**Application: SSI 7485**

I write regarding the proposed modification to M4-M5 Link, Mod 2 The Crescent overpass and changes to pedestrian infrastructure in North Annandale, Rozelle and Rozelle Bay Foreshore area.

Figure 4-2 Pedestrian and cyclist bridge infrastructure options

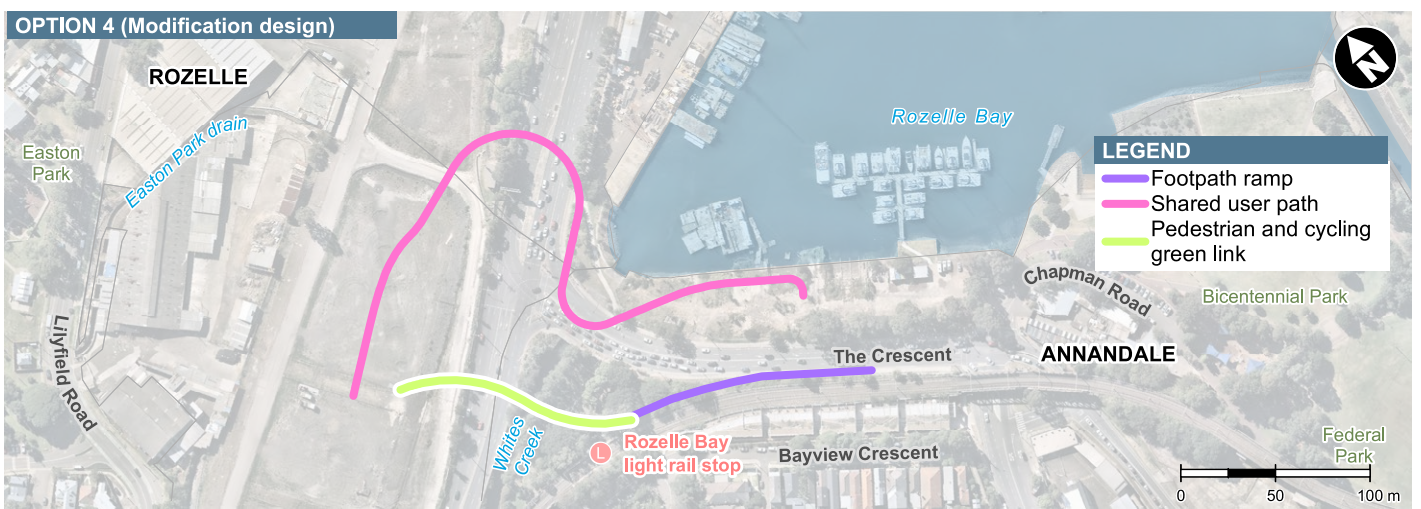
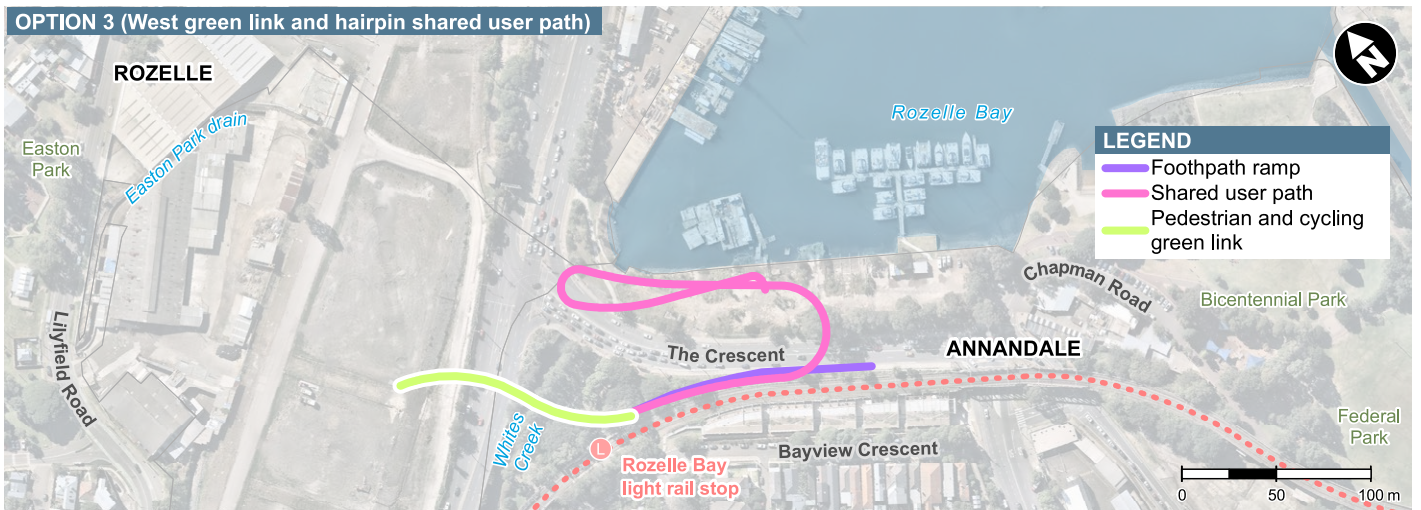
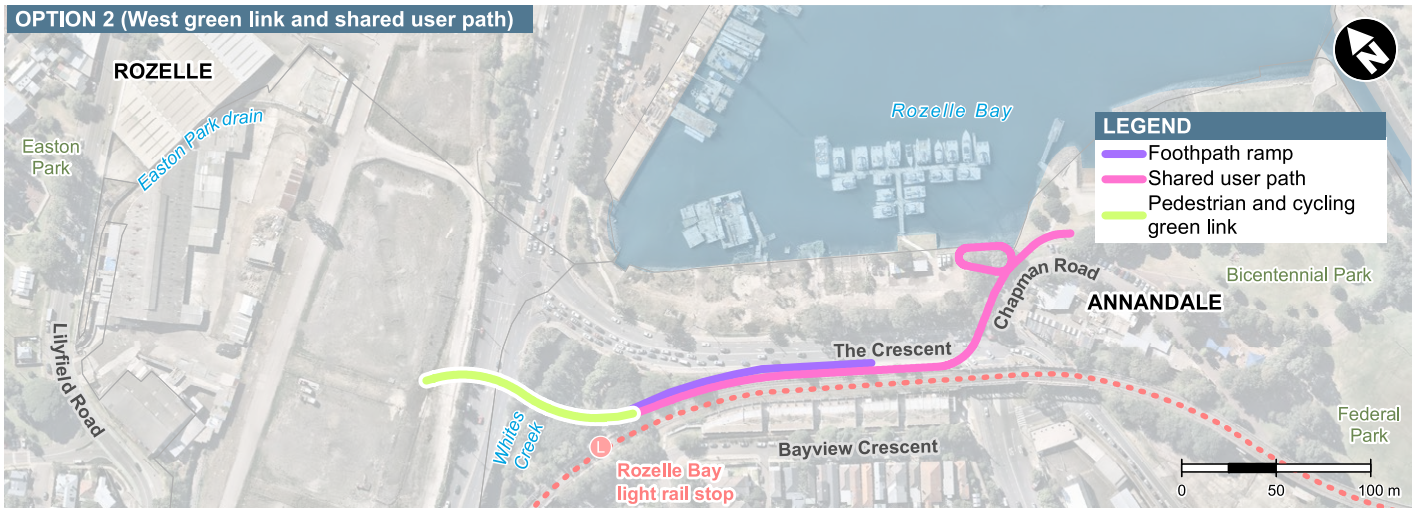
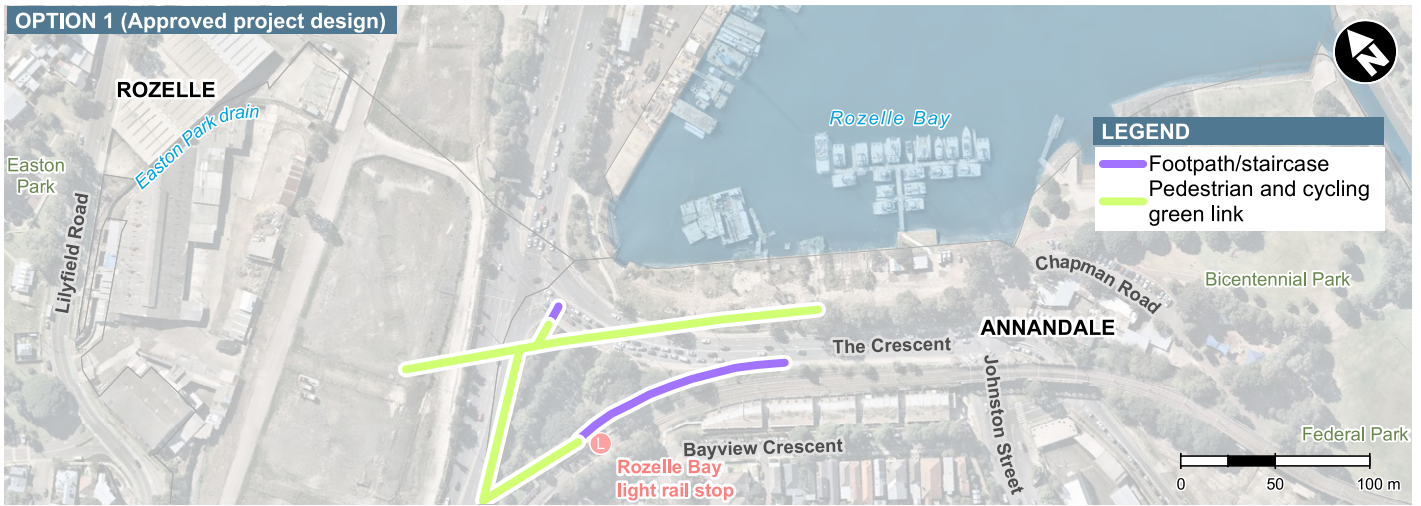
I request RMS work with the community to explore alternate design options to the proposed new car overpass design and the changed pedestrian and cyclist links. I am seeking the reinstatement of the safe, direct access from the approved EIS GreenLink to create a continuous green open space connection from the Rozelle Rail yards and Annandale to the foreshore. The GreenLink was more than just a walk way - it put people central to the design, maximising safety, and providing much needed accessible open space for the community now and into the future Bays Precinct design.

- The significantly reduced safety and increased risk for pedestrians and cyclists with removed access over The Crescent to Bicentennial Park and the increased traffic along Johnson Street.
- Being required to cross five sets of pedestrian lights at The Crescent as my option to reach the foreshore from Annandale or from Rozelle Bay light rail stop.
- Removal of direct active links to the foreshore, cutting the community off from the area and the proposed revitalisation of the entire Bays Precinct, including linking the Light Rail and Bus stops to a Ferry wharf and Metro station.
- Urban and landscape design that is being built before a finalised Masterplan for the area.
- Traffic changes that limit movements around the suburb and create further congestion in the local streets of Annandale, Forest Lodge, Glebe, Lilyfield and Rozelle with no planning to deal with these.

- Reinstate the GreenLink connecting communities and green open space from Rozelle to Bicentennial Park
- Relocate and design pedestrian and cyclist connections that are continuous, safe and direct.
- Design the modification infrastructure and active links in response to the character of the suburbs, the location of the foreshore and it's potential future development.
- Provide pedestrian and cyclist paths that maximise people safety and do not force them onto busier streets, unsafe concrete plazas and caged walkways.
- Integrate active and direct connections to all active transport – including the future Metro West and Foreshore Ferry Wharf

Figure 4-3 The Crescent, Johnston Street, Chapman Road intersection options

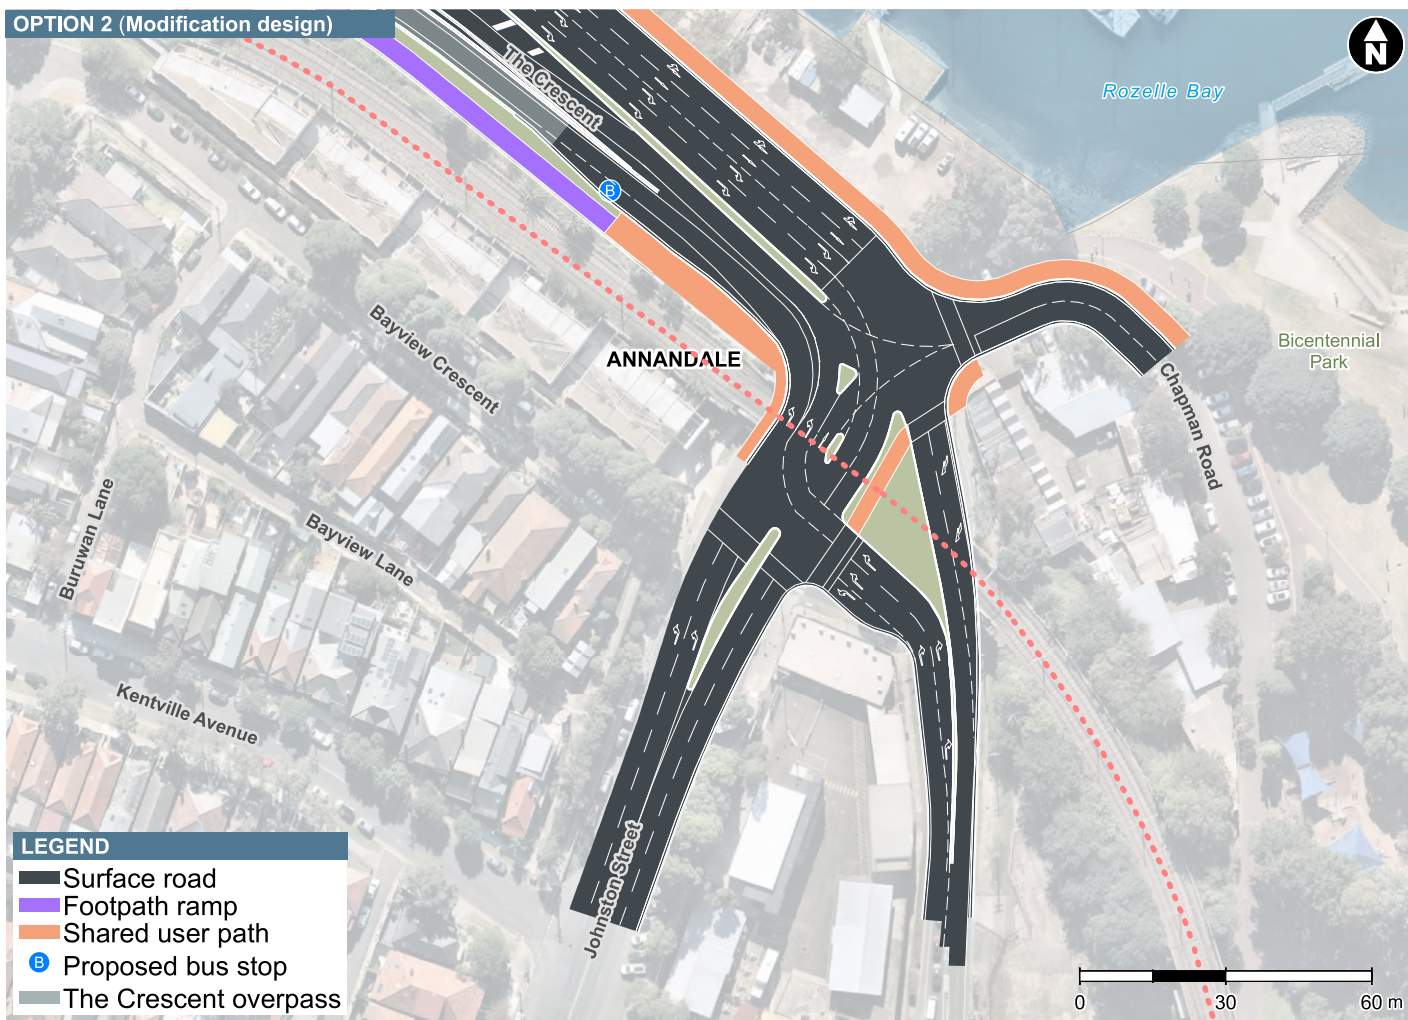
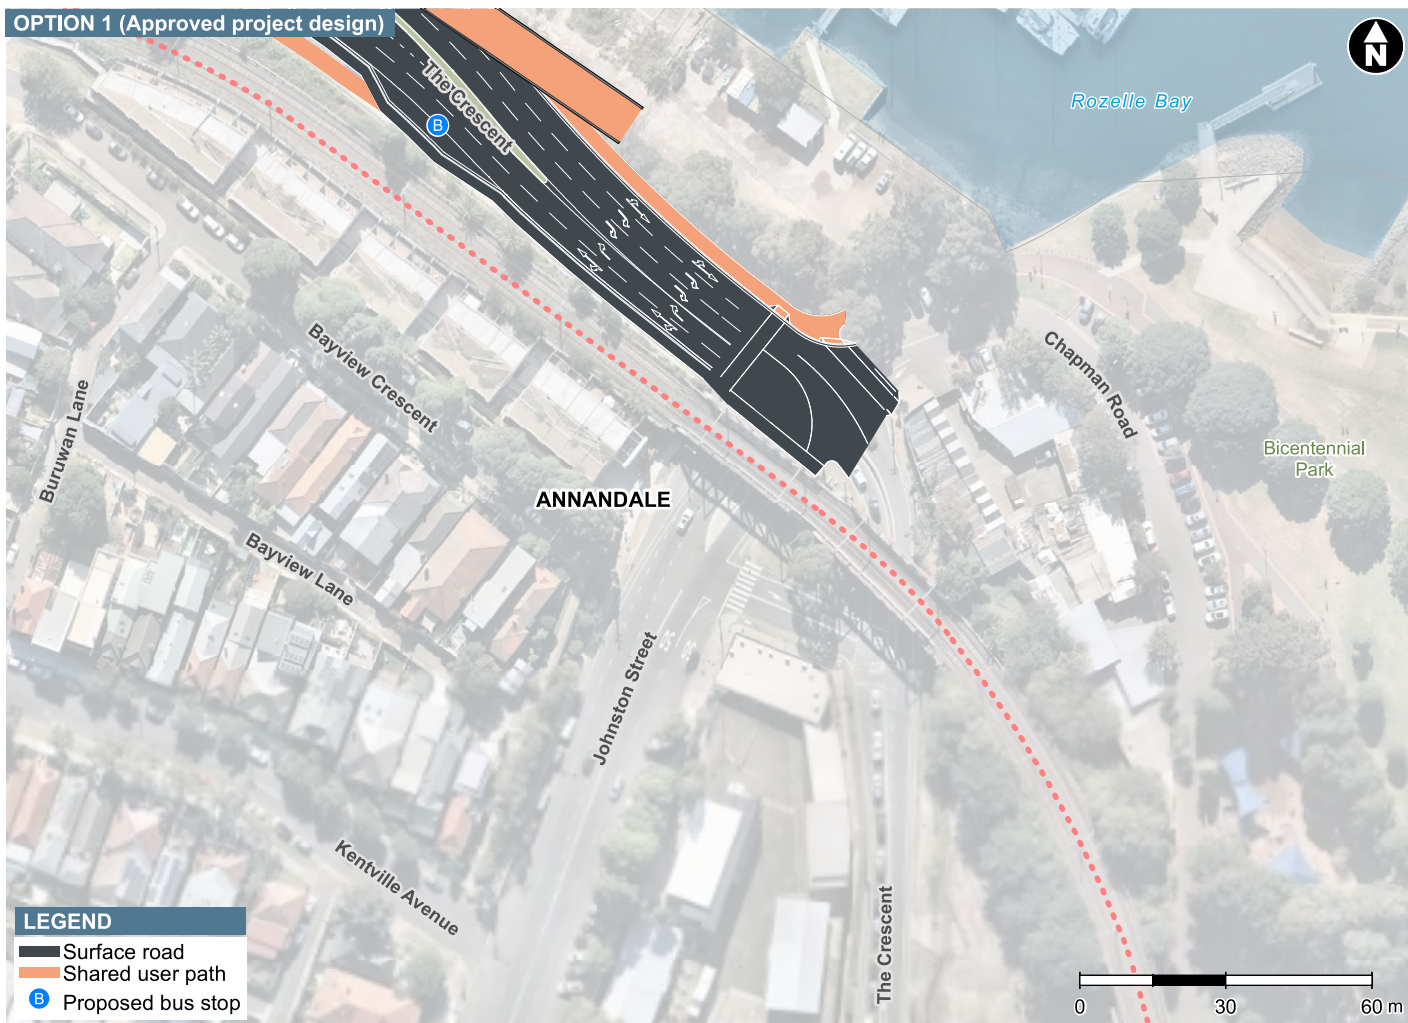
*My family and I visit The Foreshore Park 1 to 2 times a day. We live on the North side of Annandale + cross at the lights at The Crescent + Johnston. The changes to this area would make it unsafe + too difficult for us to continue to do so. We have a toddler and a dog and so navigating five sets of lights + busy roads, with groceries usually bought at The Tramsheds would just not be feasible. Please consider the impact to the local way of life, our environment + local businesses.*
